Subject: RE: Planning Consultation on FP/42/19/DOC

Engineers Comments Regarding Condition 7

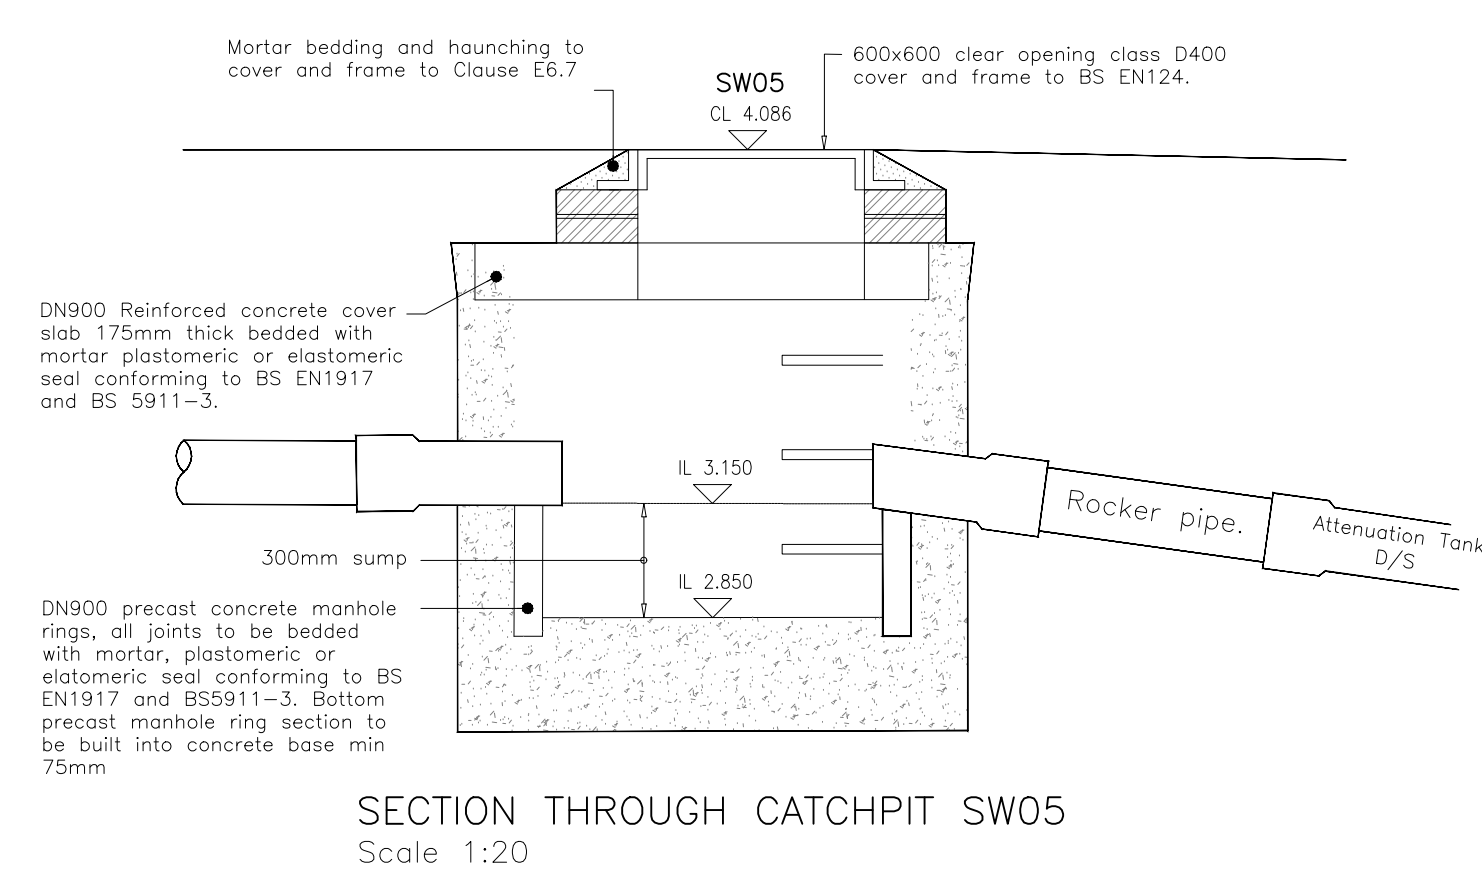
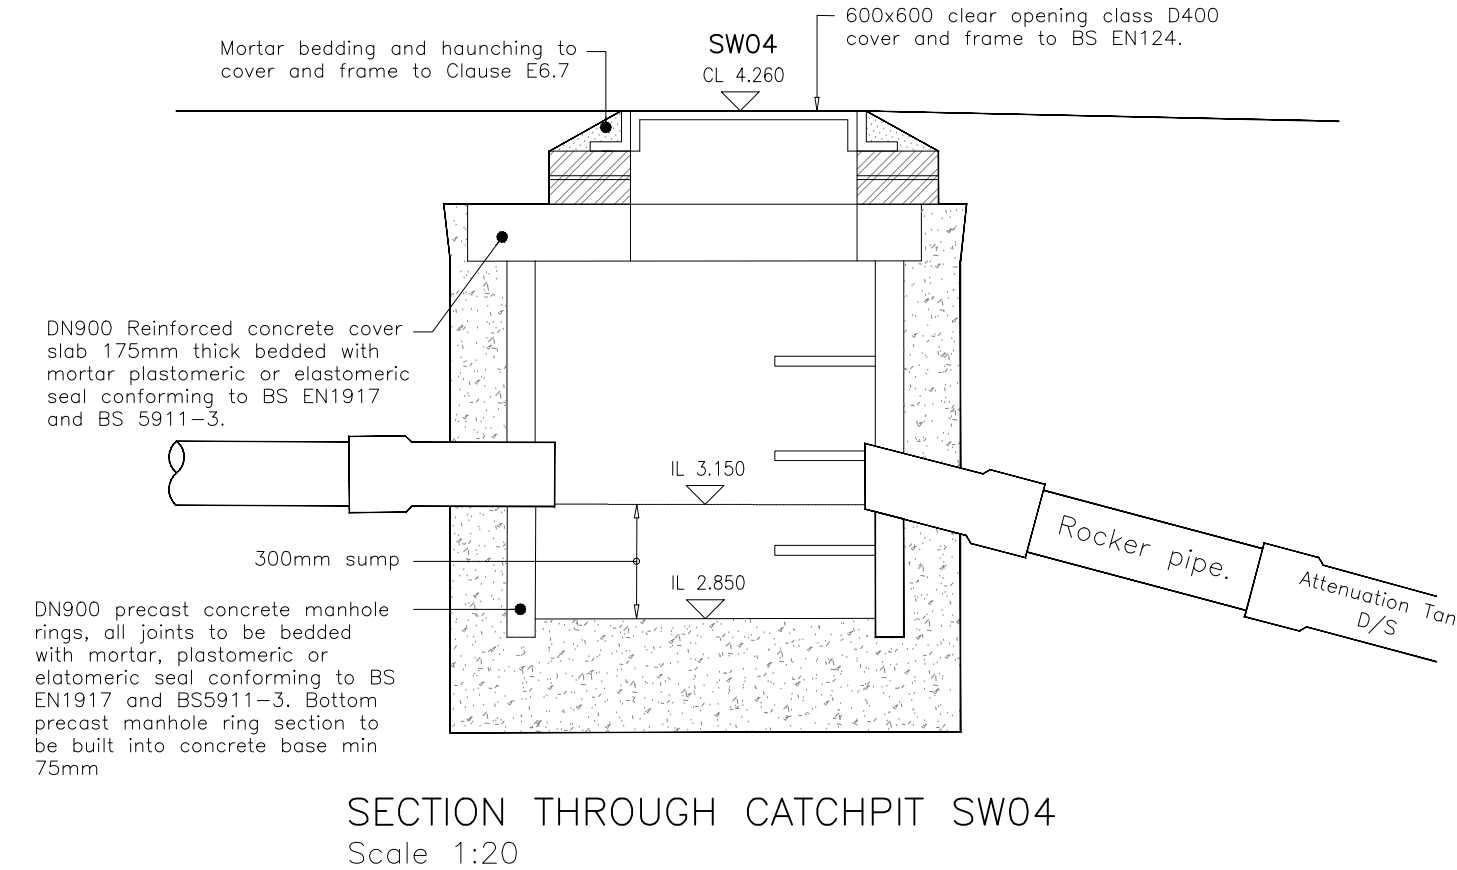
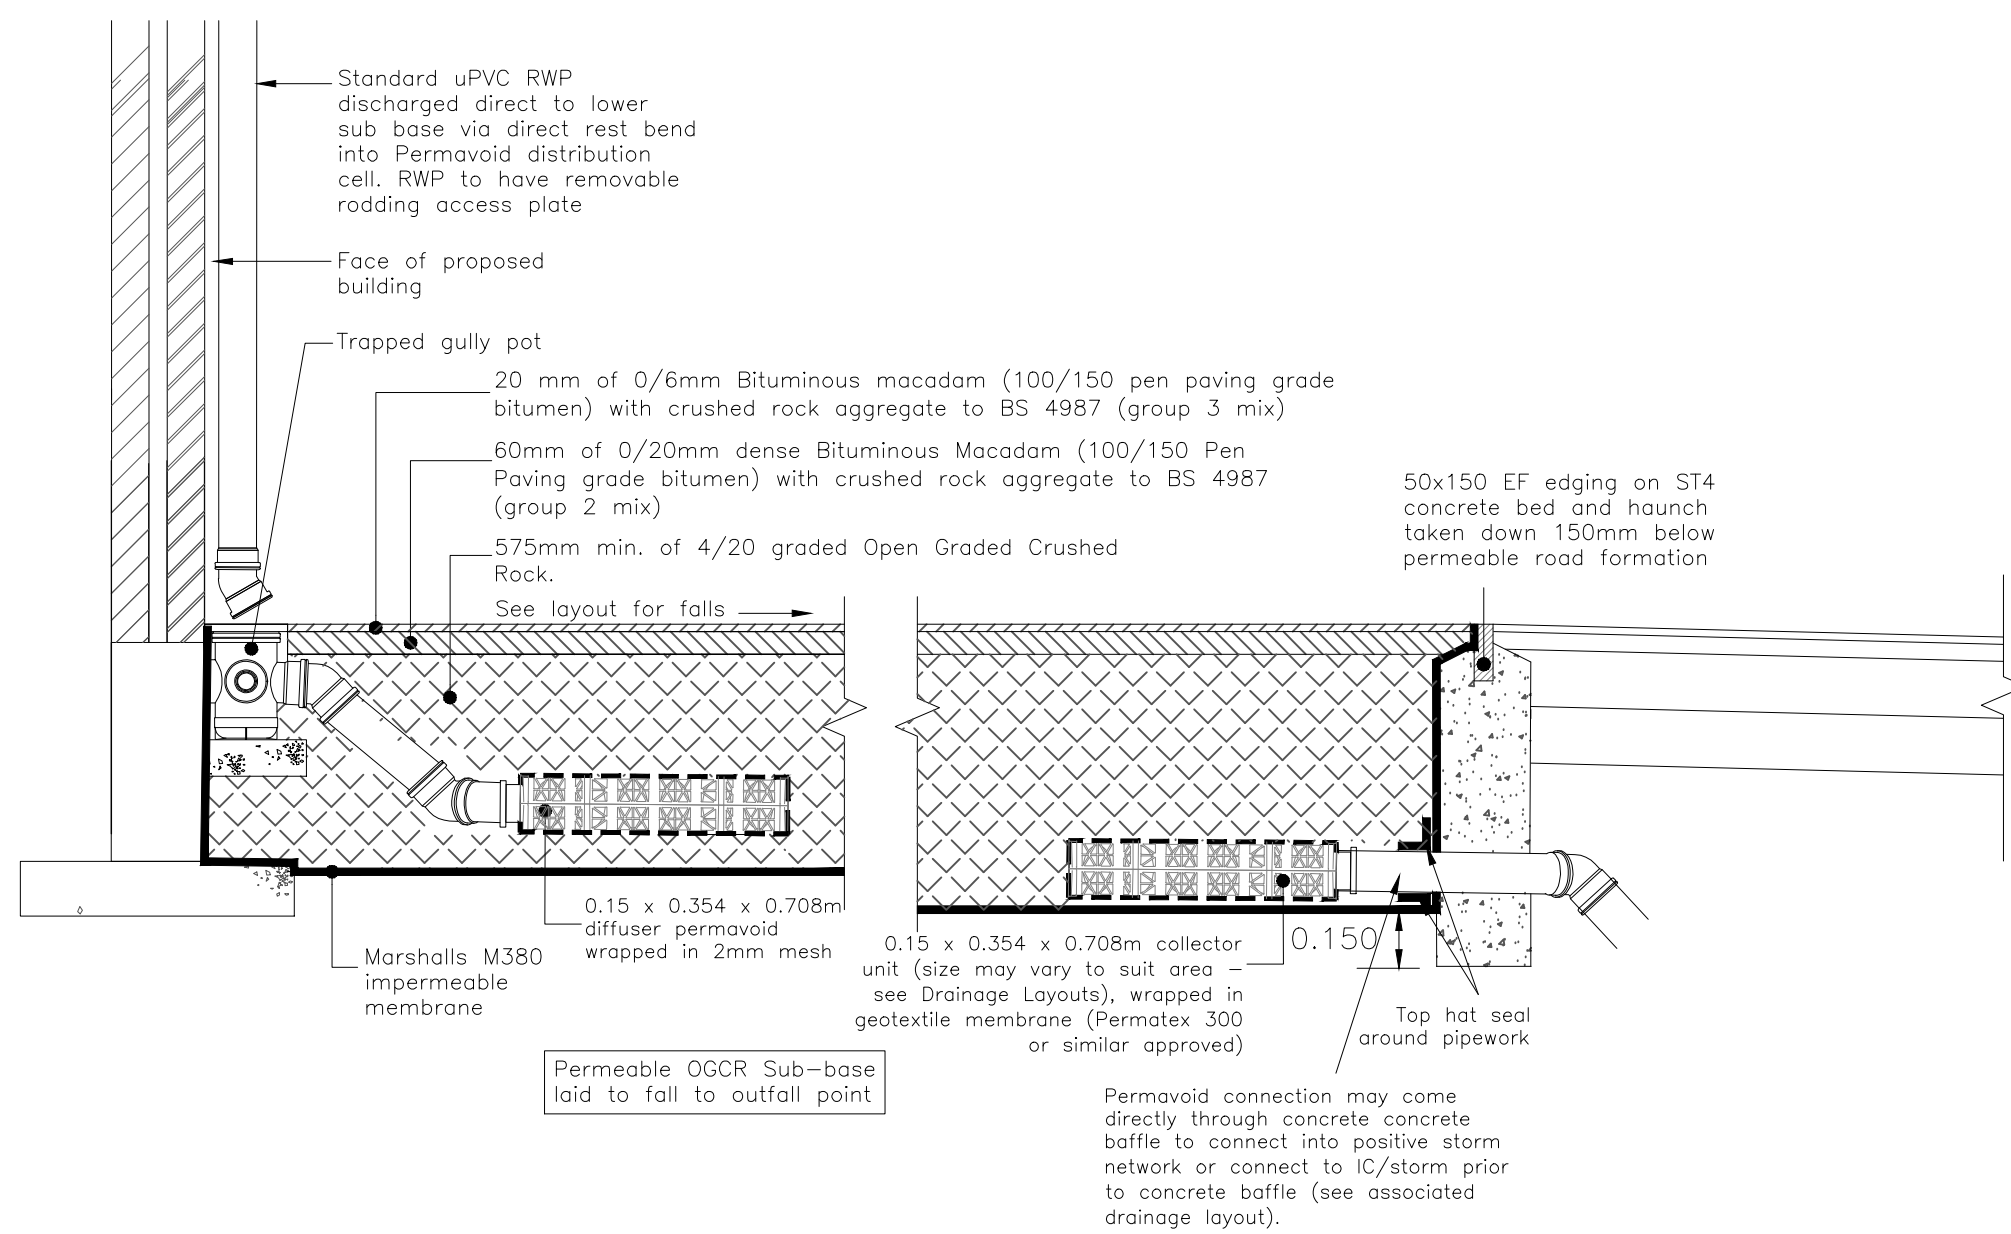
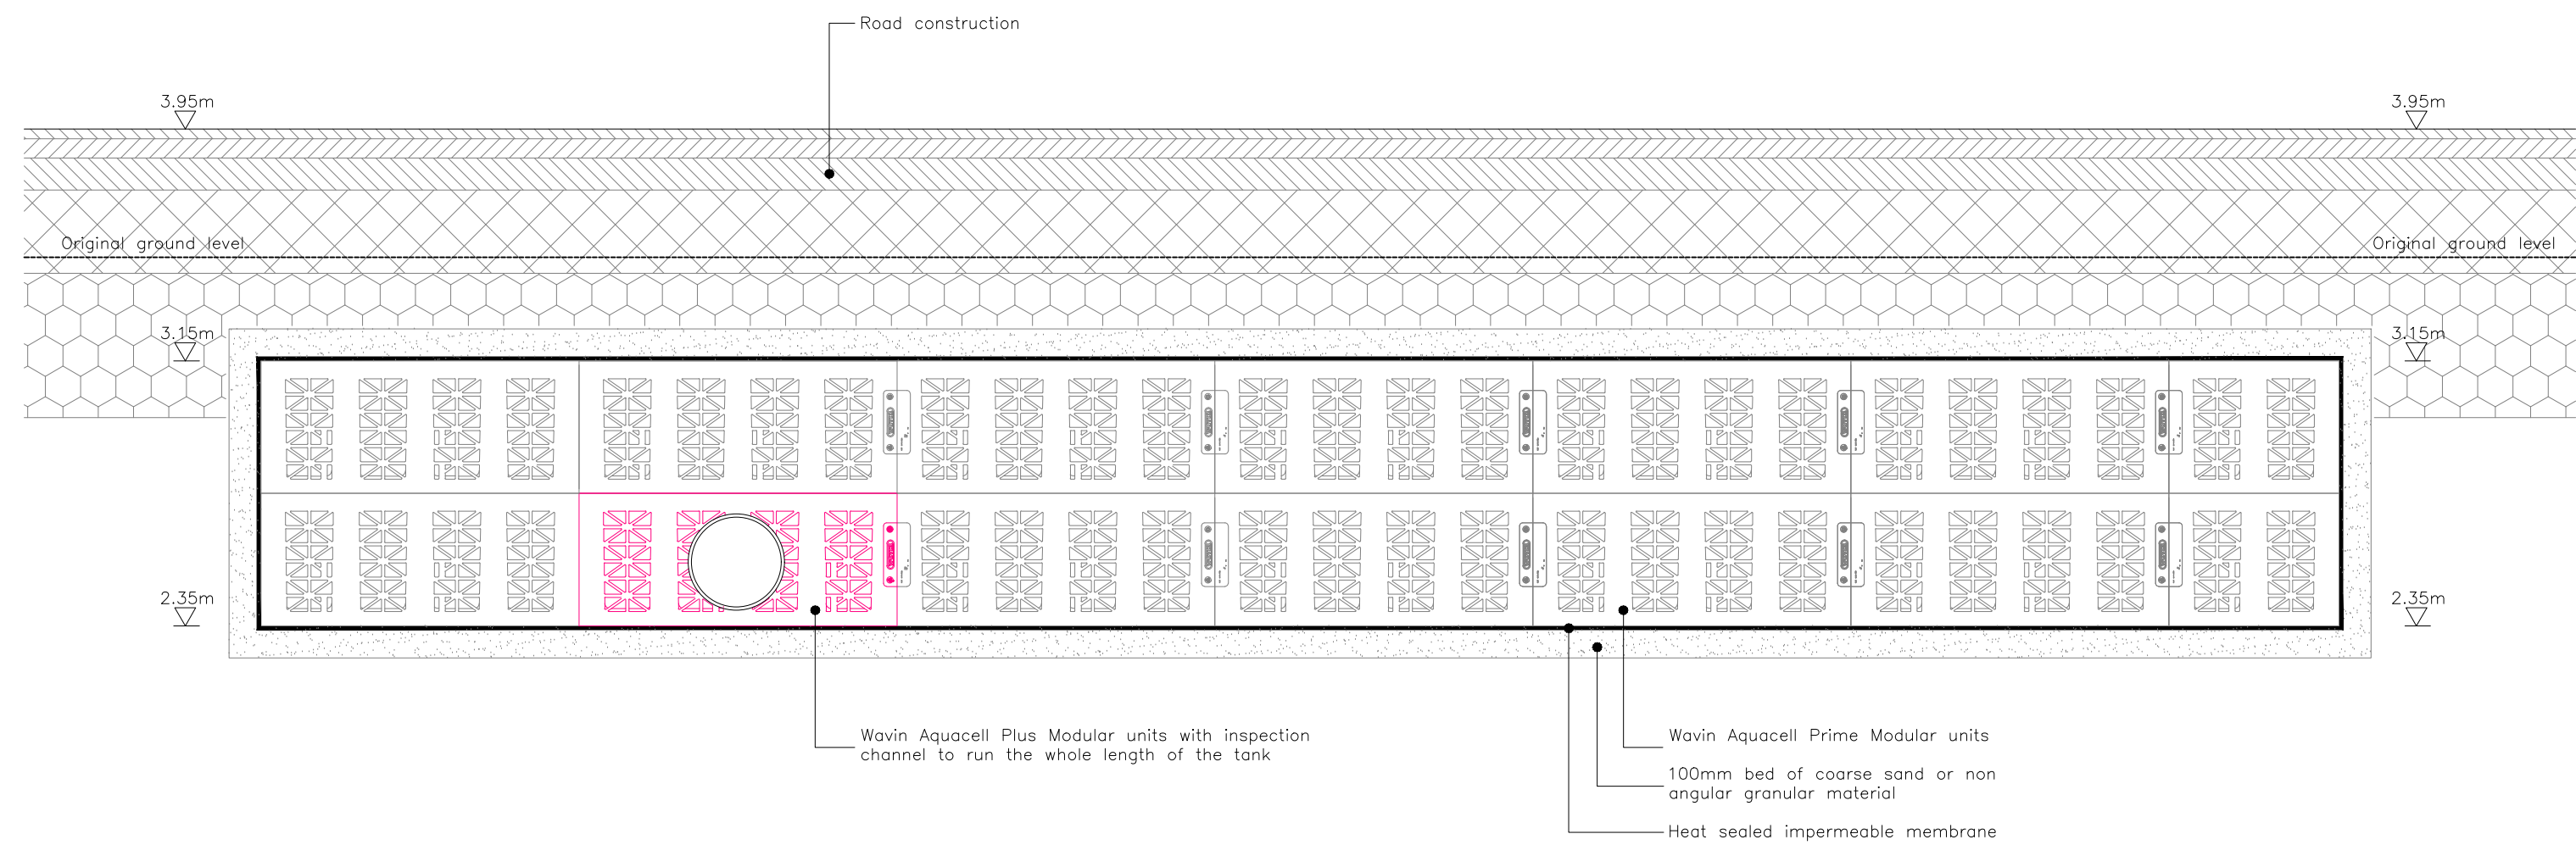
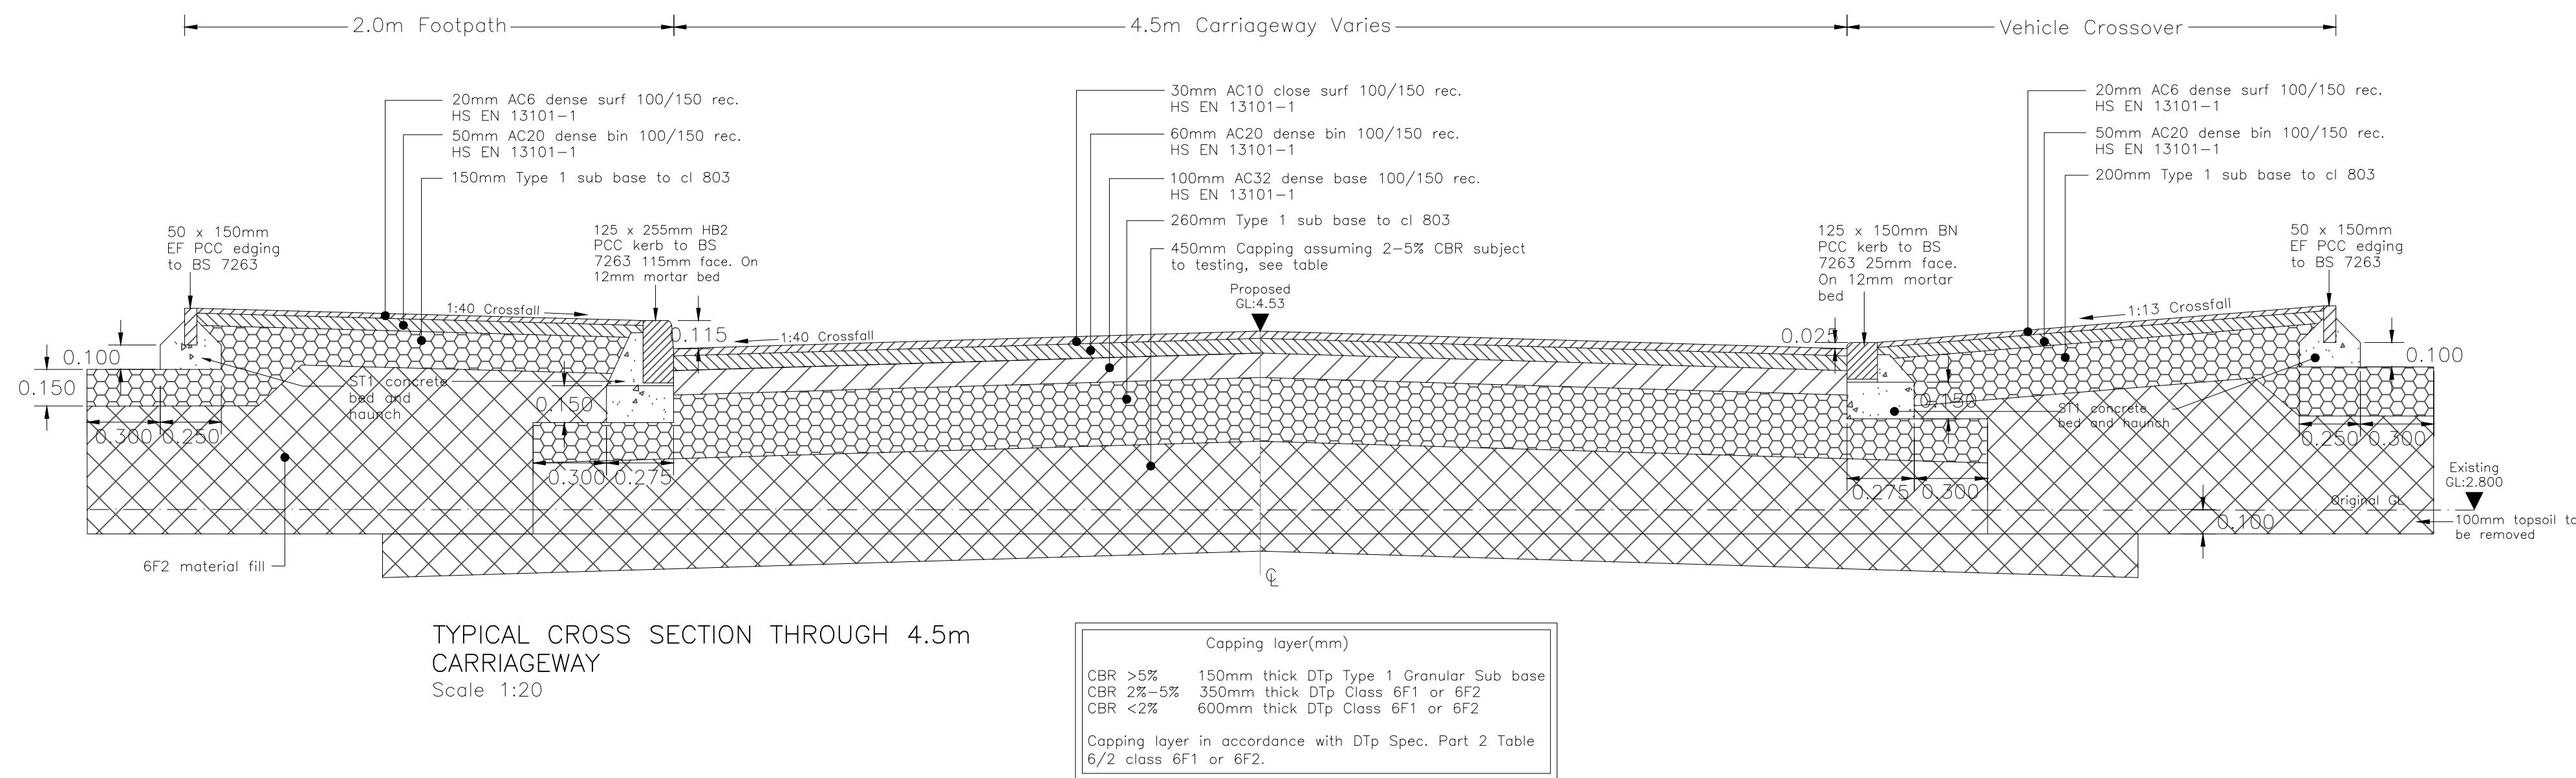
1. Catchpits must be provided upstream of all connections into the attenuation tank.
Please refer to drawing 5782:23 Construction Details demonstrating manhole SW04 and SW05 should be installed with 300mm deep catchpits.
